CITY OF ALBUQUERQUE

March 28, 2023

**Re: Take 5 Express Car Wash
98th St. and Sage Rd. SW
Traffic Circulation Layout
Engineer's Stamp XX-XX-XX (M09-D035)**

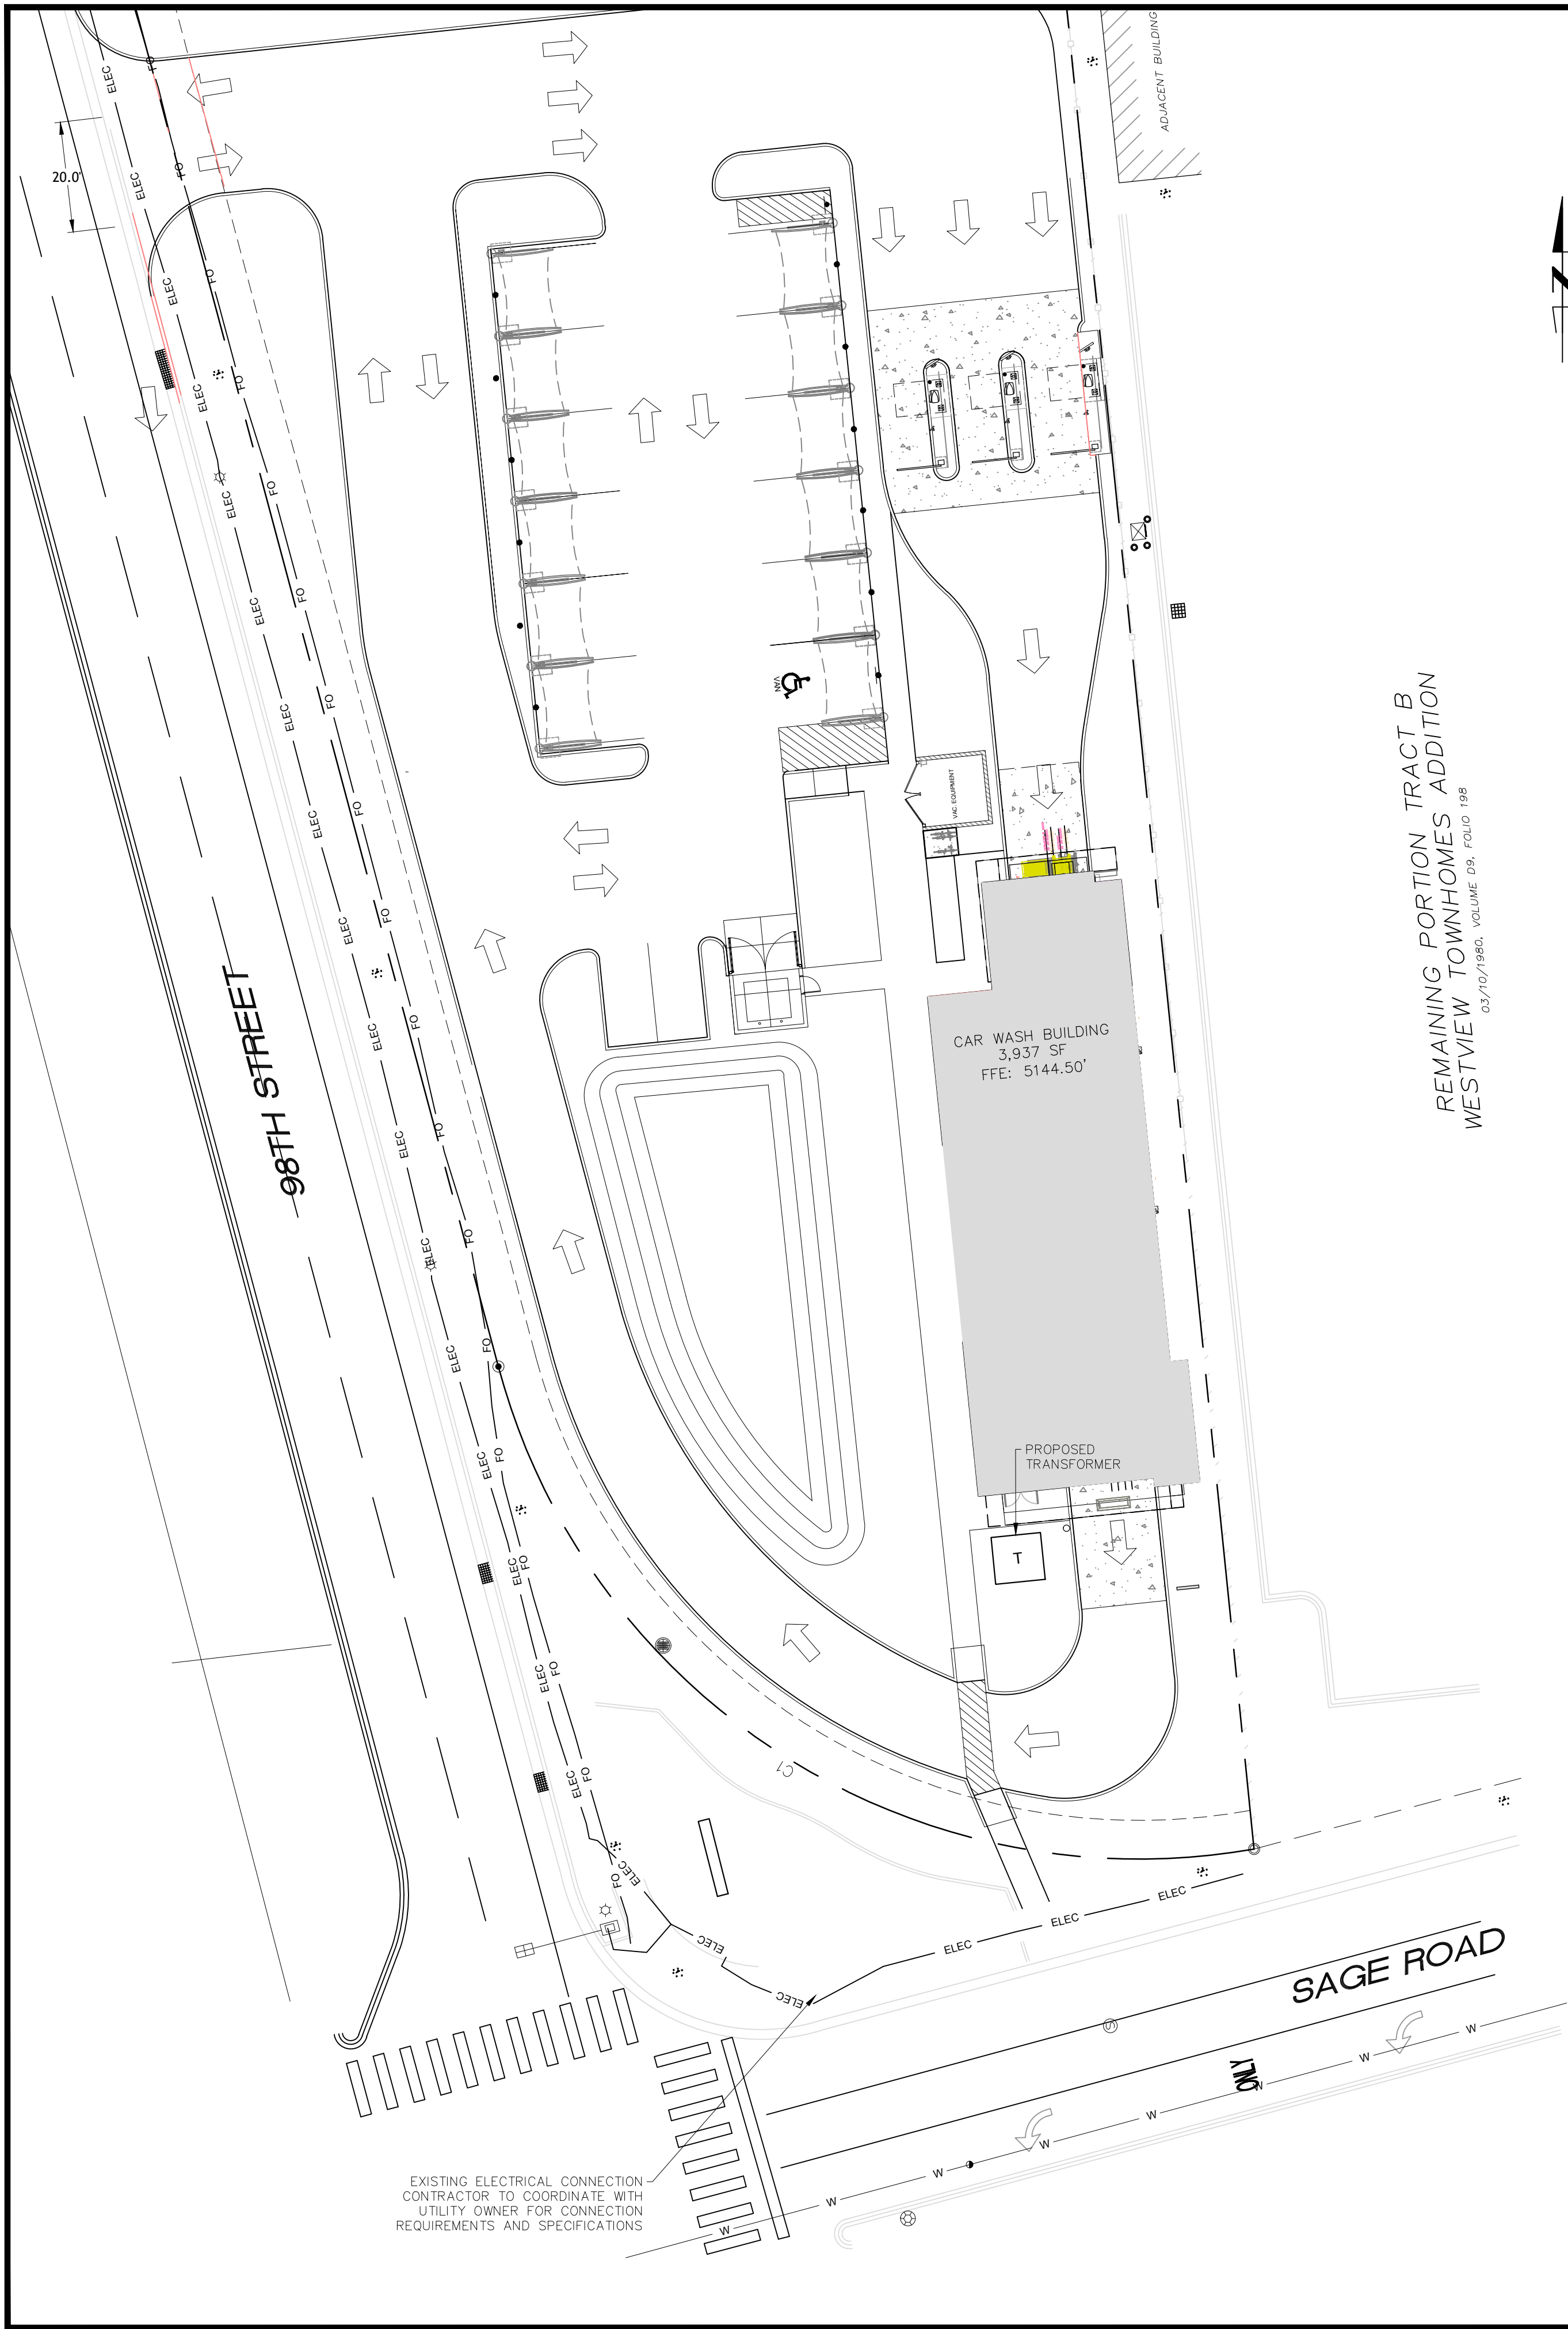
1. The traffic circulation layout must be dated by an engineer or architect licensed in the state of New Mexico.
2. Define the property line.
3. Details sheet is missing. Please provide details for driveway access, proposed signs, and proposed interior ADA ramps.

4. Site plan showing 7' wide curb cut off 98th St. Please clarify, is this a curb cut or it is a storm drain inlet?
5. The ADA accessible parking sign must have the required language per 66-7-352.4C NMSA 1978 **"Violators Are Subject to a Fine and/or Towing."** Please call out detail and location of signs.

6. Please show Motorcycle and Bicycle parking spaces on the site plan, and provide details.
7. Please provide Motorcycle parking space sign posted upright, either free-standing or wall mounted per the zoning code.

8. Refuse vehicle maneuvering shall be contained on-site. The refuse vehicle shall not back into the public right of way.; provide a copy of refuse approval.

9. Provide a copy of Fire Marshal approval.
10. Please provide "One Way" signage and pavement markings at the entrance of the drive-thru lanes on the north east side of the building. Please show detail and location of posted signs and striping.
